Recommendation Report for Planning Permission for Works or Extension to a Dwelling

REF NO: P/36/22/HH

LOCATION: Sefter Cottage
Pagham Road
Pagham
PO21 3PX

PROPOSAL: Erection of two storey rear extension.

Job Number: AR-170 Drawing Number: 01 Revision: Revision

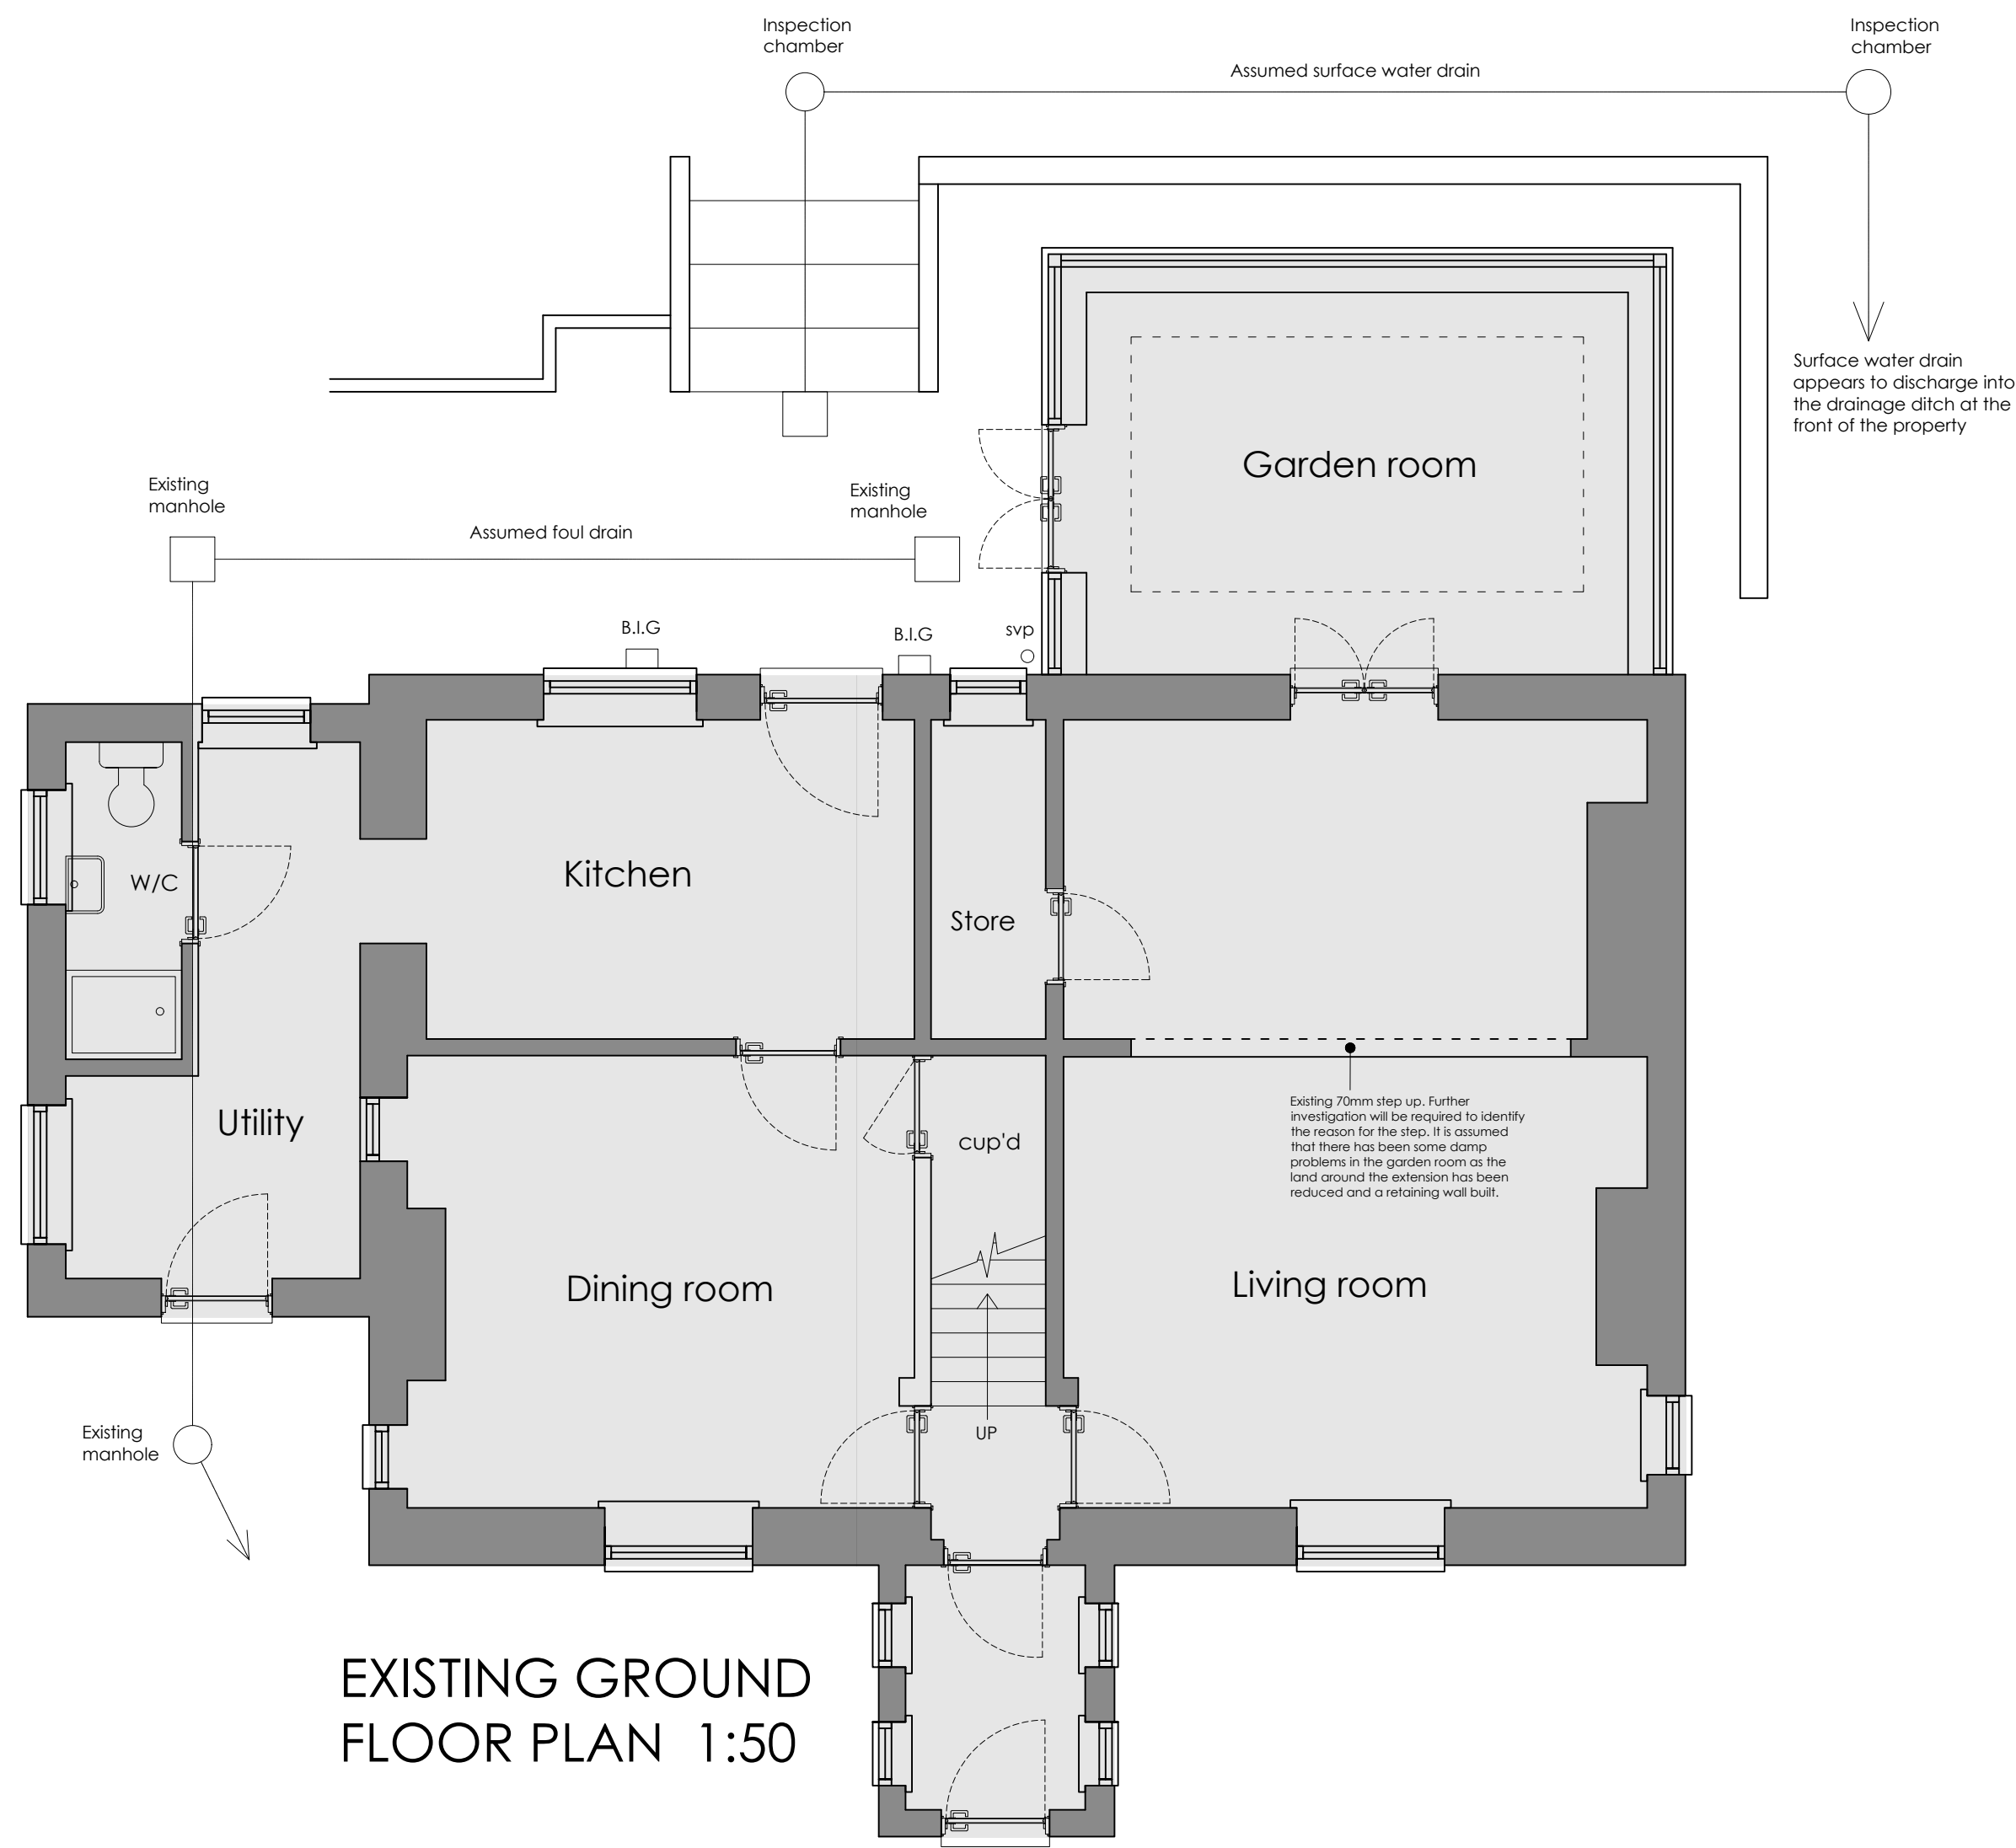
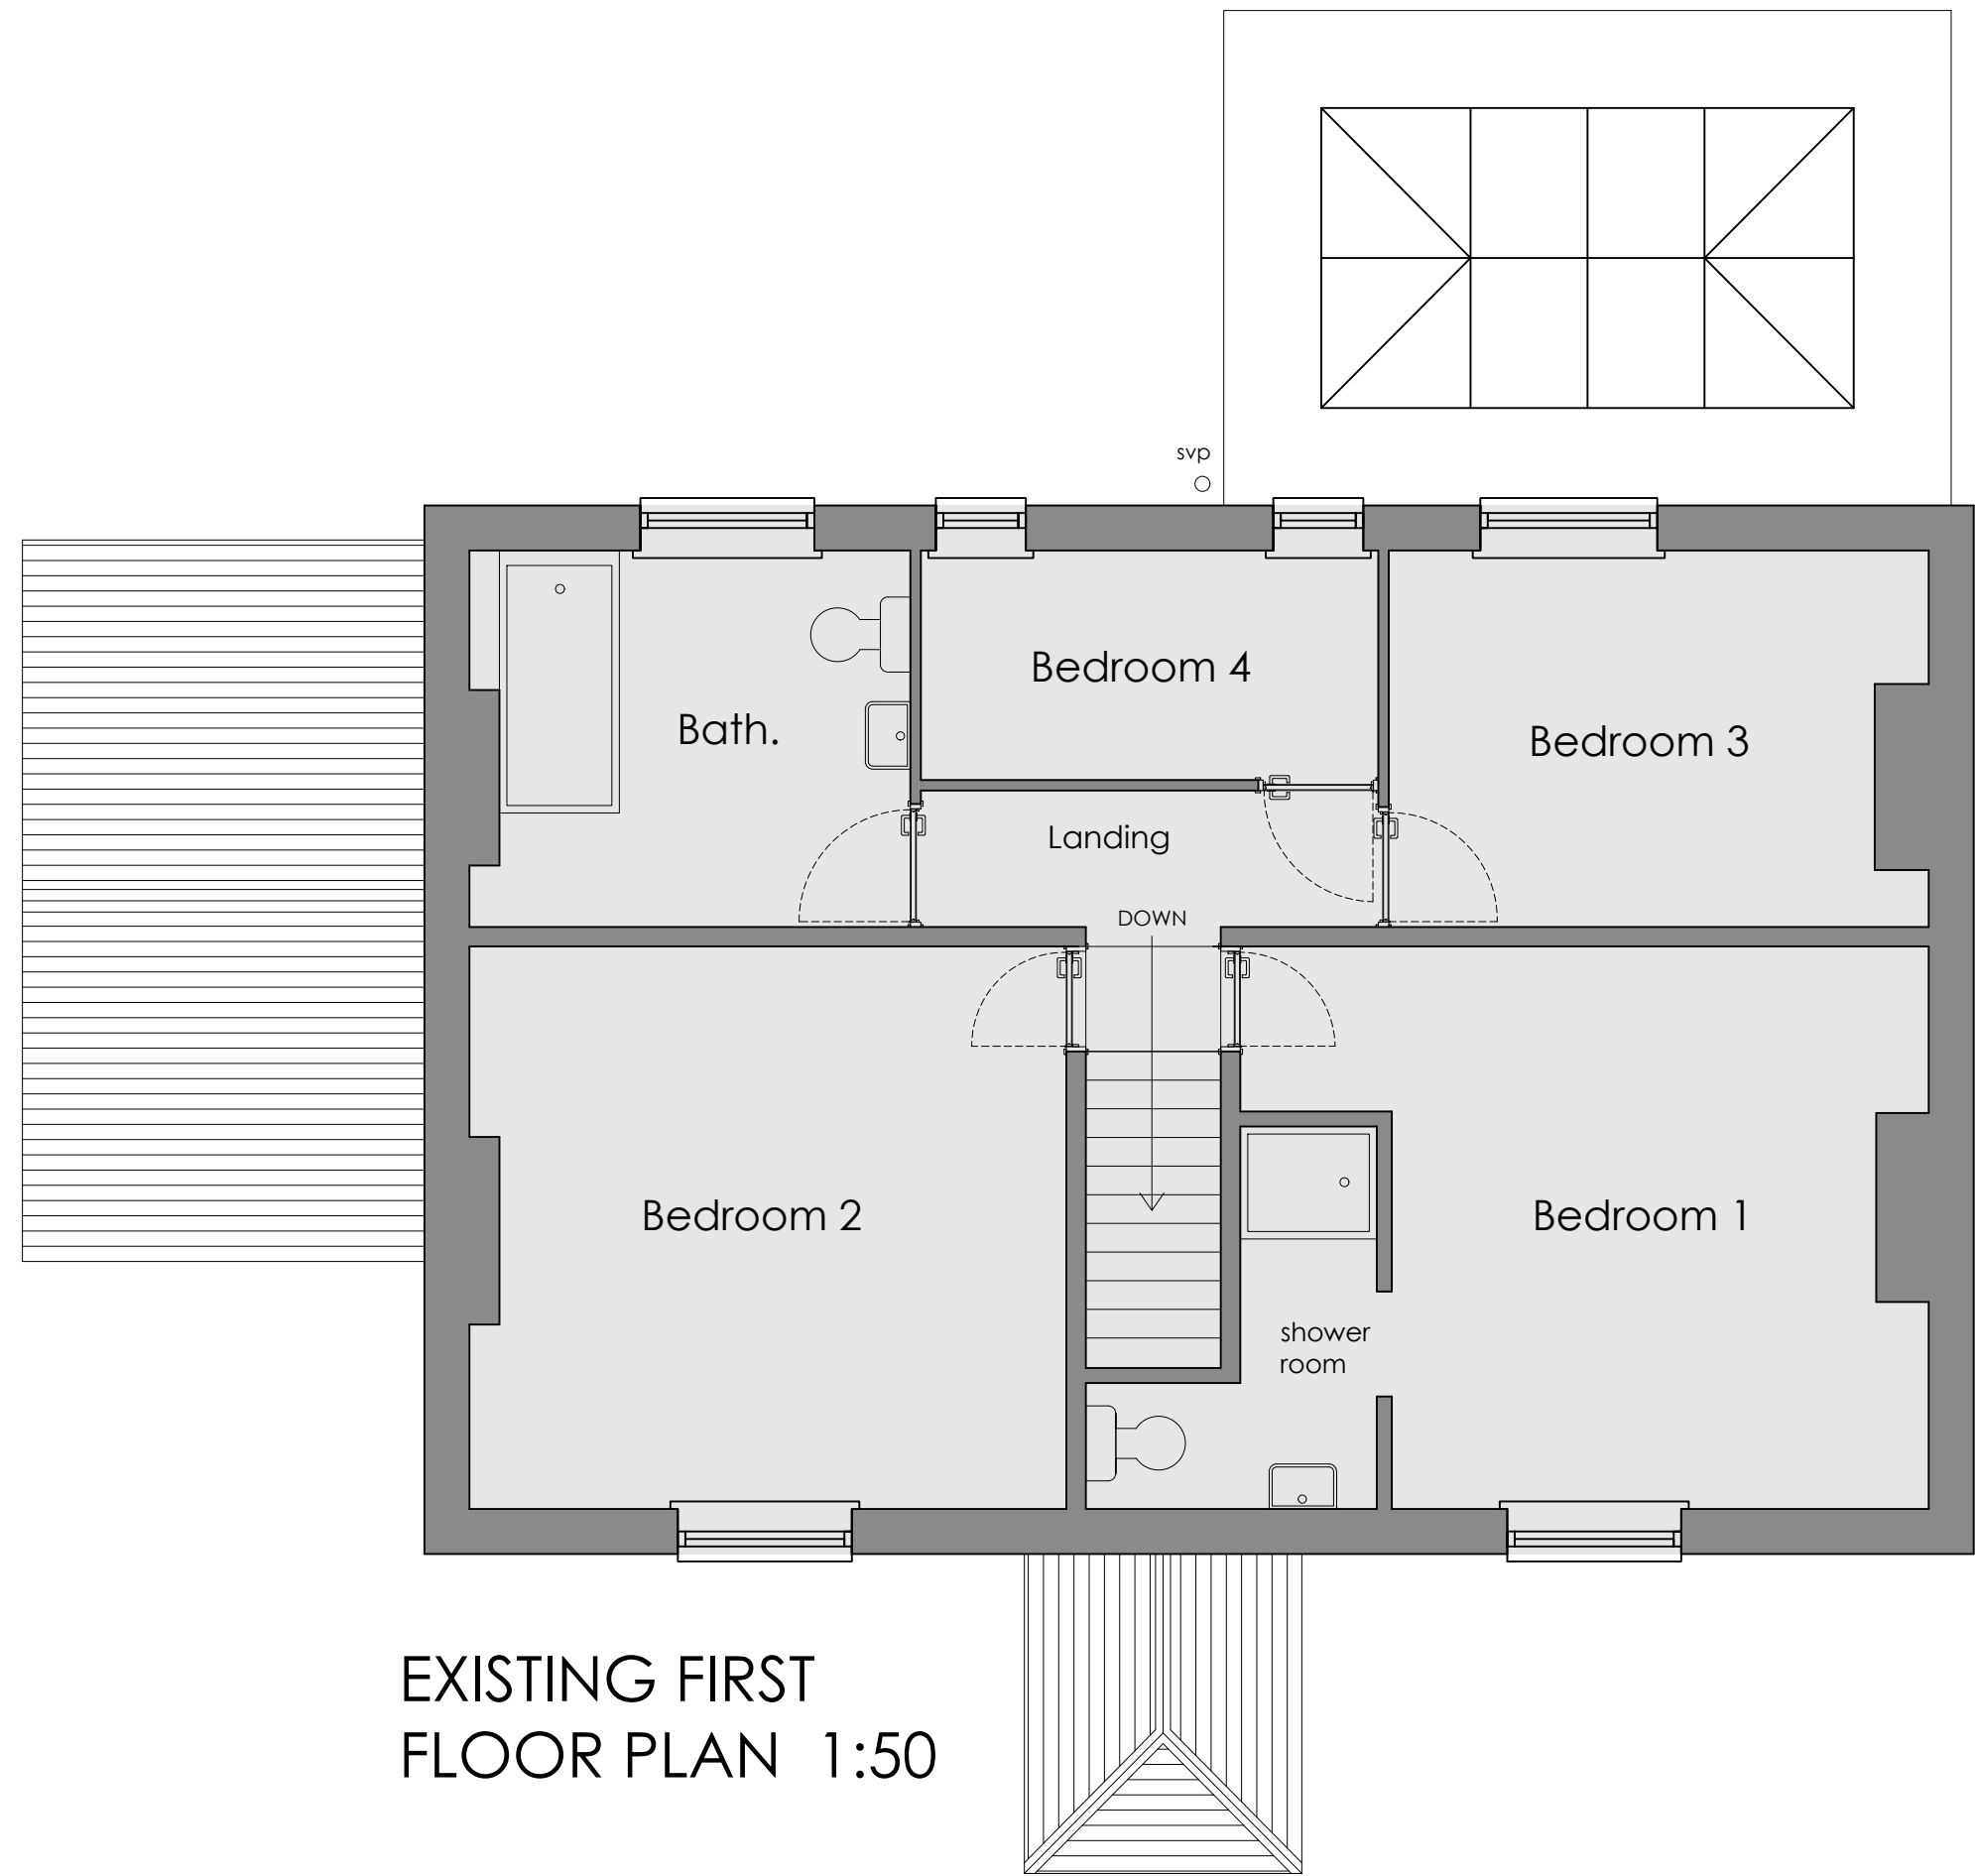
The extension will retain 12m to the rear boundary and 13.5m to the northern side. There are no neighbours to these elevations and the proposal will not result in harm upon these elevations.

2.3m is retained to the south western boundary. Rookery Cottage is located to the south although is located a sufficient distance away as not to result in adverse overbearing or overshadowing impacts.
